INNER WEST COUNCIL

**SUBMISSION FROM INNER WEST COUNCIL
TO THE DEPARTMENT OF PLANNING, INDUSTRY & ENVIRONMENT (DPIE)
ON MODIFICATION 3, WESTCONNEX STAGE 3 (M4-M5 LINK):
IRON COVE VENTILATION UNDERGROUND (SSI-7485-Mod-3)**

DECEMBER 2019

**Figure 5 | Alignment of proposed tunnel and caverns at Iron Cove**  
(Source: Iron Cove ventilation underground Modification Report)

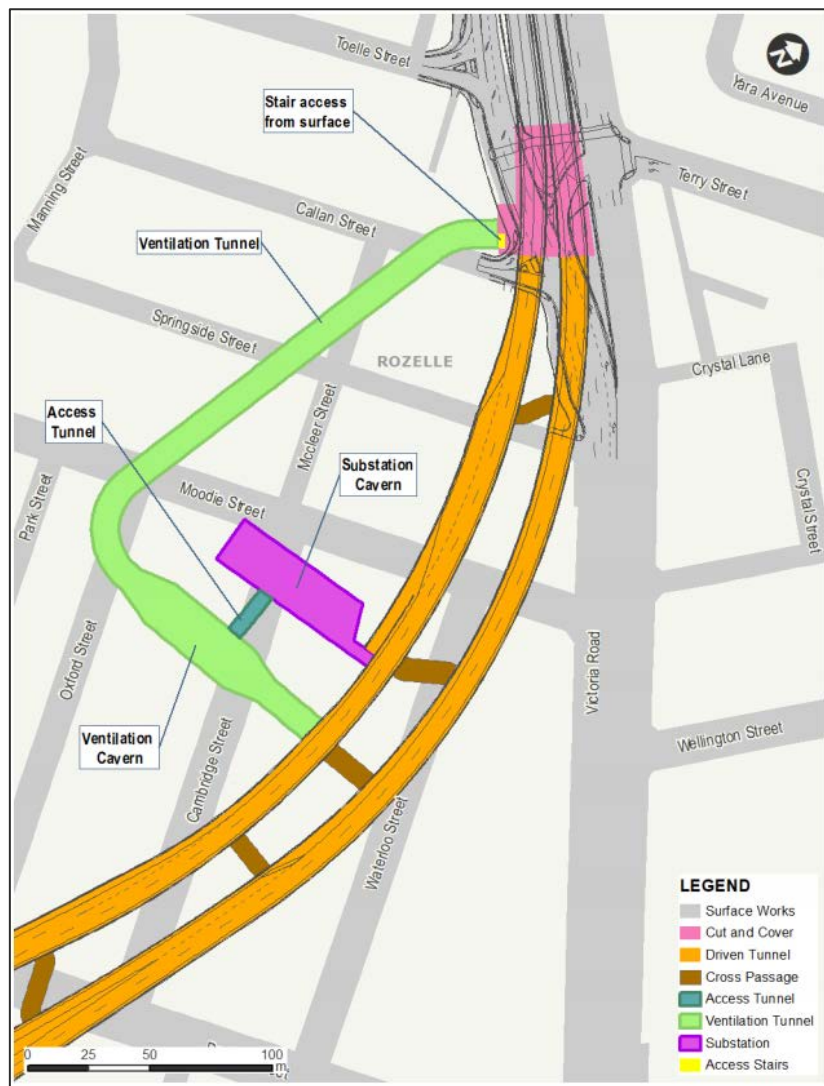
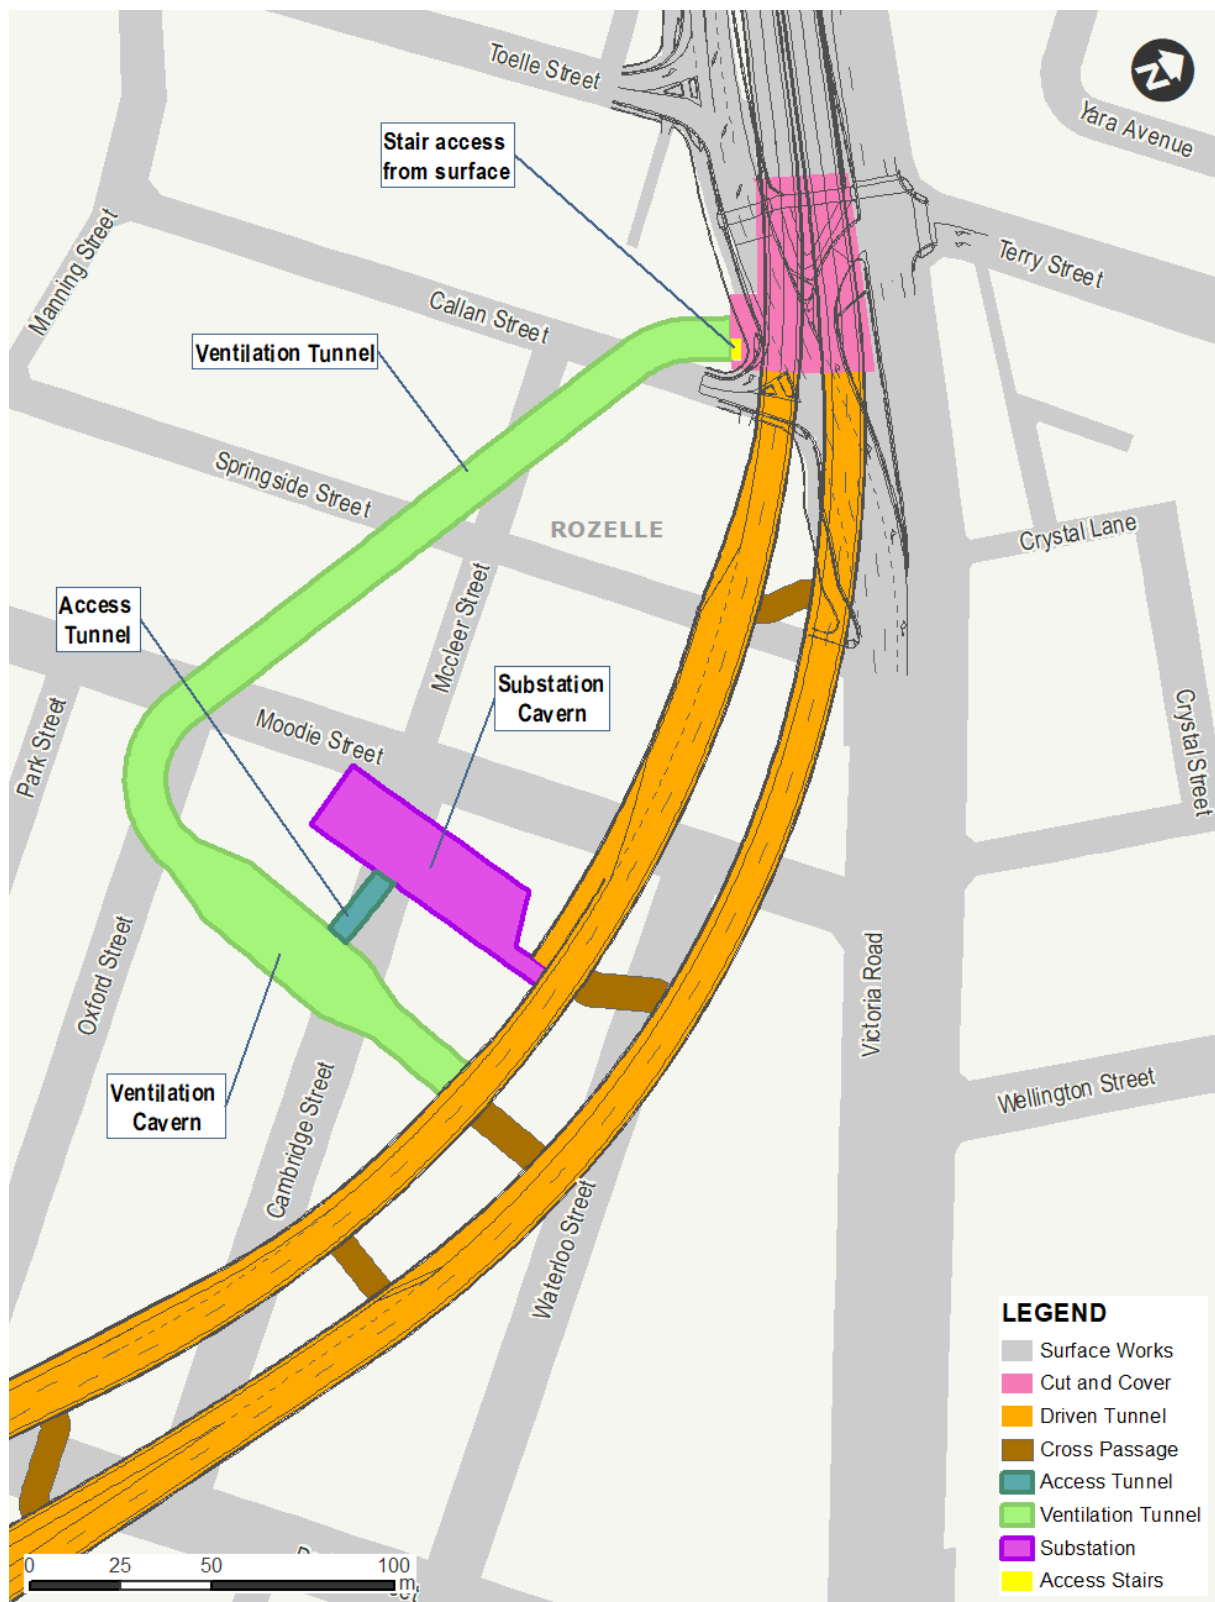
The proposed new ventilation tunnel and associated caverns would have a total length of about 425m, with about 20m of access tunnels connecting the caverns. The new tunnels and caverns, ranging from 8 to 30m in depth, would extend beneath homes in Callan Street, Waterloo Street and Cambridge Street in Rozelle.

The modification report states that areas subject to settlement would change, with areas not previously identified by the EIS to now be affected. Ground settlement from tunnel construction and the resulting damage to properties has been a significant concern for Inner West residents, as is evident by the numerous EIS submissions that had raised this issue.

Council has been contacted by property owners who have said they were concerned about property damage, but were not approved for property condition reports. Extension of the tunnelling associated with this modification should be backed by a commitment from the contractor to support all property owners who are concerned about tunnelling impacts even if they are outside the 50m zone.
